**WRITTEN REPRESENTATION FOR  
SPR EA1N and EA2 PROJECTS (DEADLINE 1)**

**Interested Party:** SASES    **PINS Refs:** 20024106 & 20024110

# East Anglia ONE North & East Anglia TWO: Cultural Heritage Assessment

prepared for  
Substation Action Save East Suffolk (SASES)

Figure 5: Outline Landscape Mitigation Plan and Relevant Heritage Assets in the vicinity of Friston

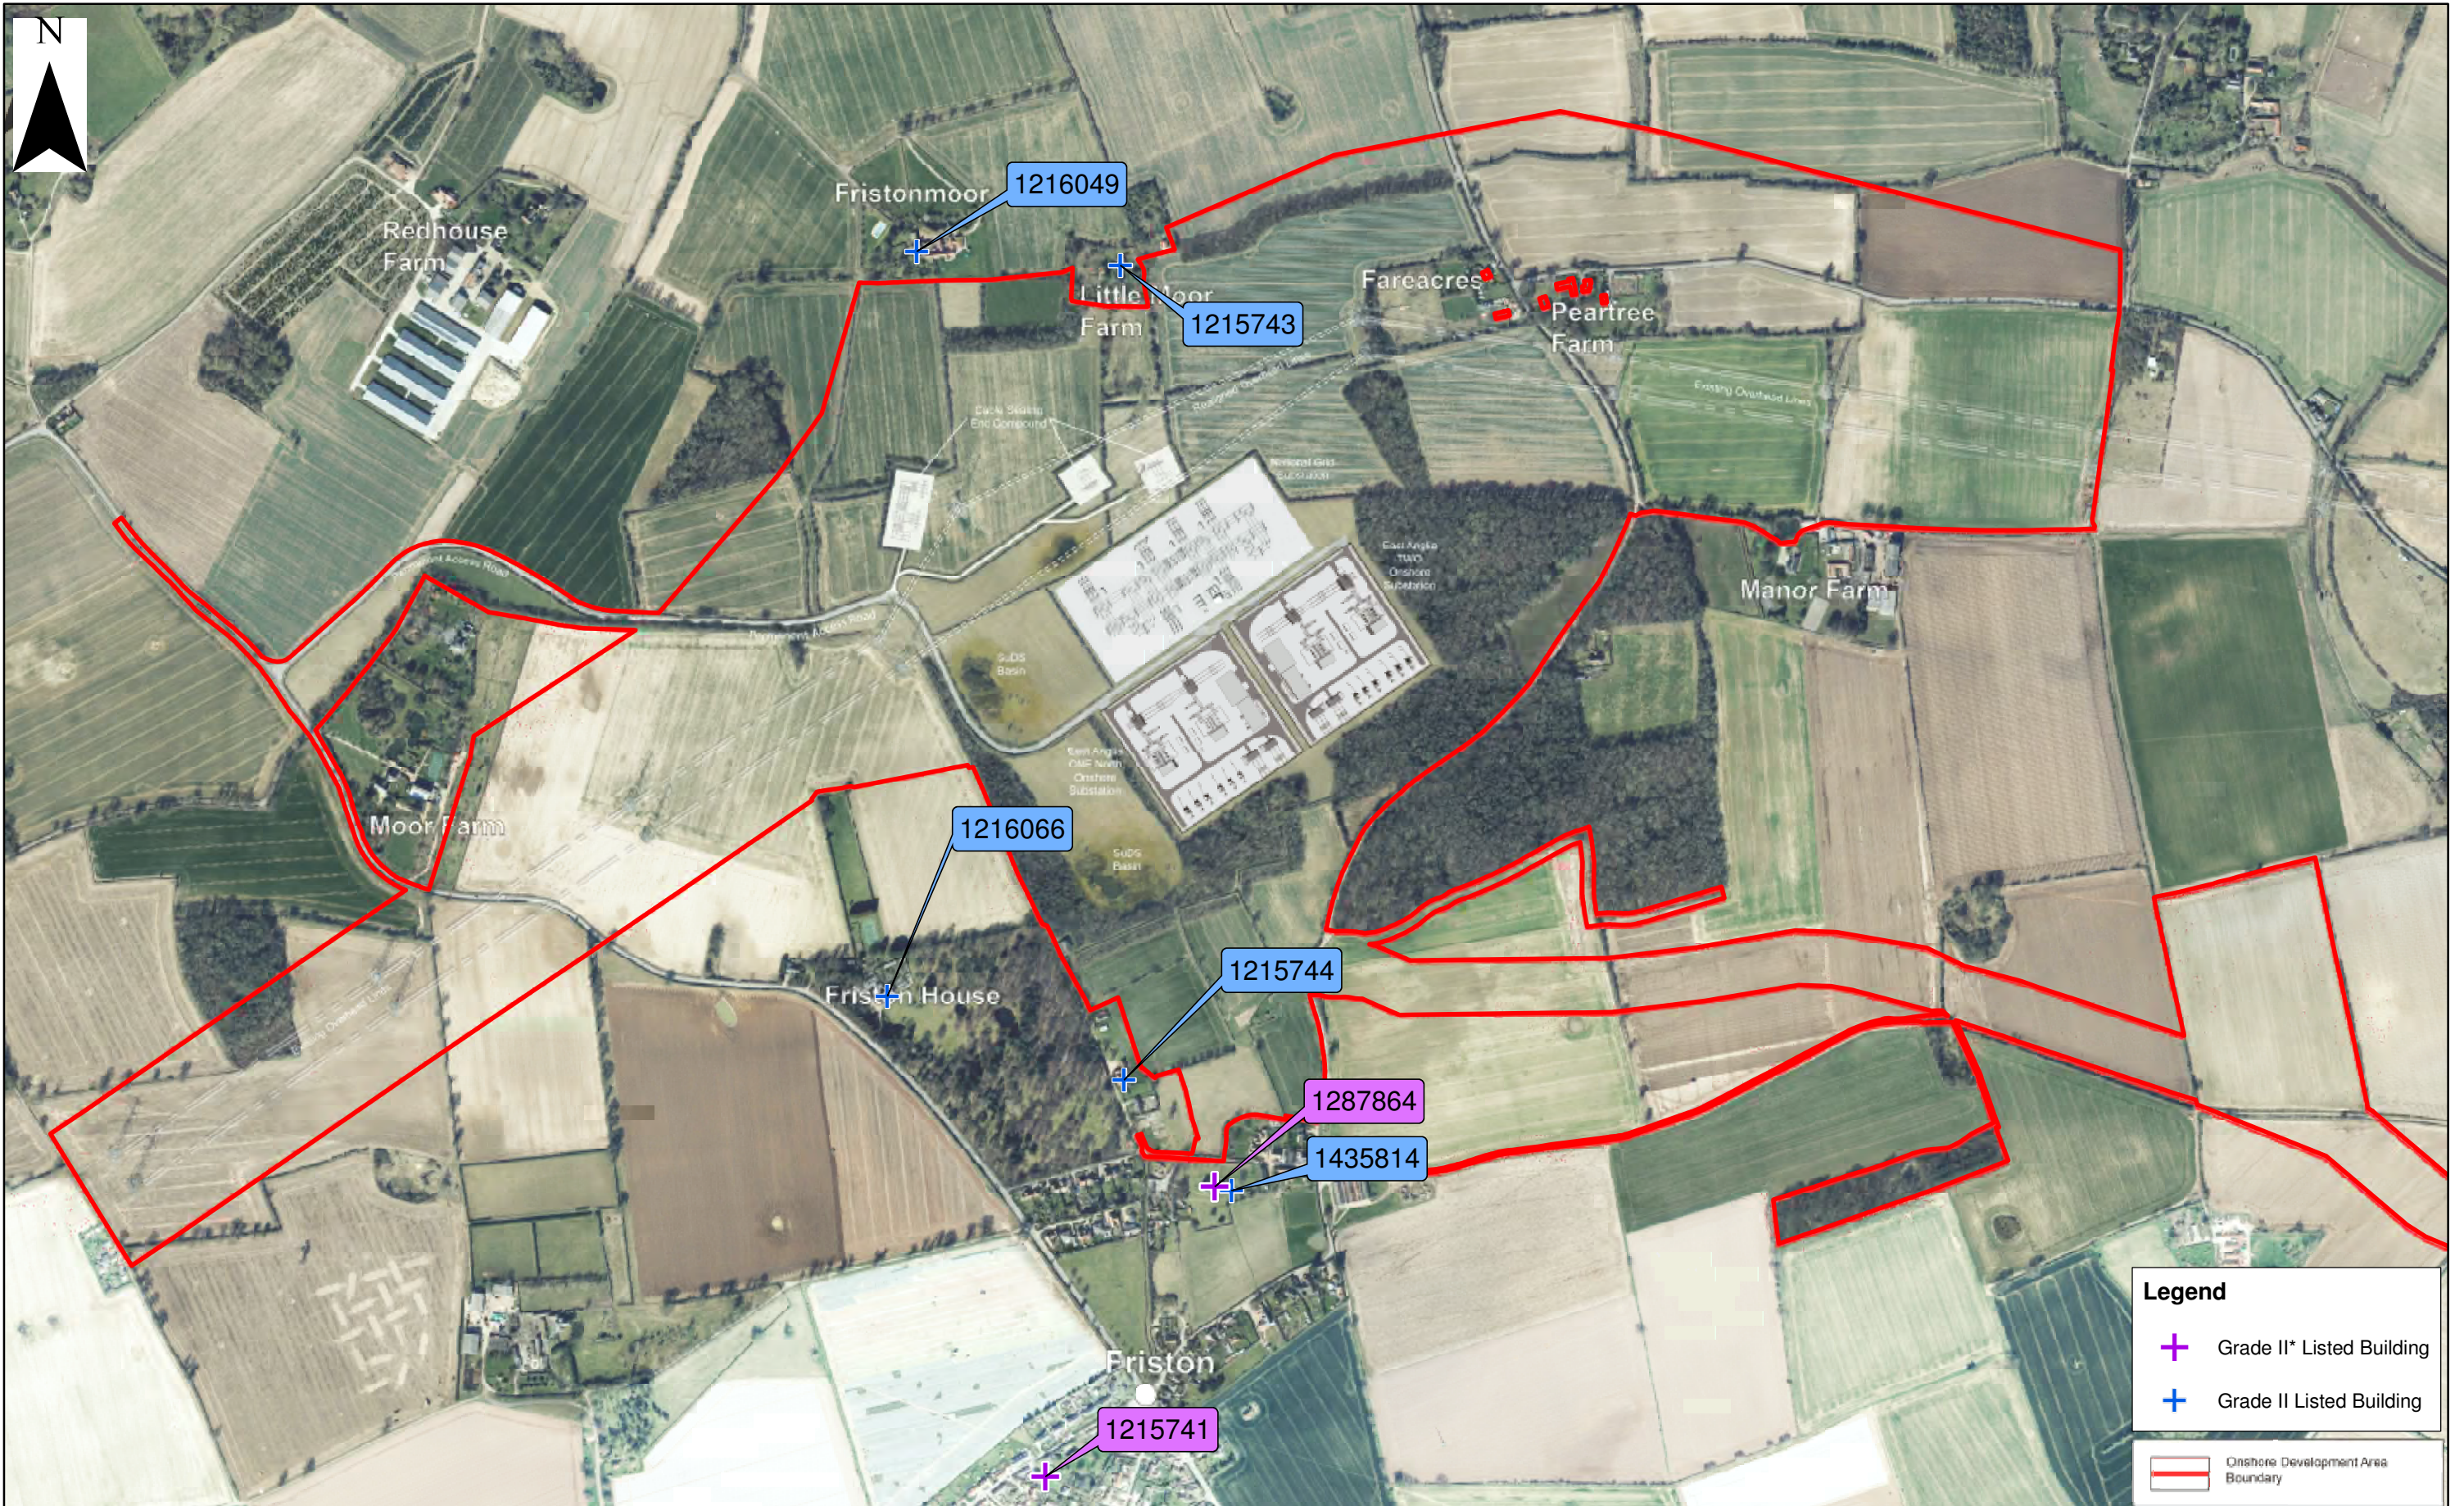
The submitted assessments also demonstrate that the mitigation measures put forward in the proposed Outline Landscape Mitigation Plan do nothing to reduce the heritage impacts of the schemes in any meaningful way. In six of the seven instances where harm is identified, the applicant acknowledges that the proposed mitigation planting will be of such negligible effect that even after 15 years it will not have had sufficient effect to reduce the assessment of harm caused to any of the heritage assets. In short, by the applicant's own admission, the proposed mitigation scheme is not fit for purpose and will not reduce the heritage harm.
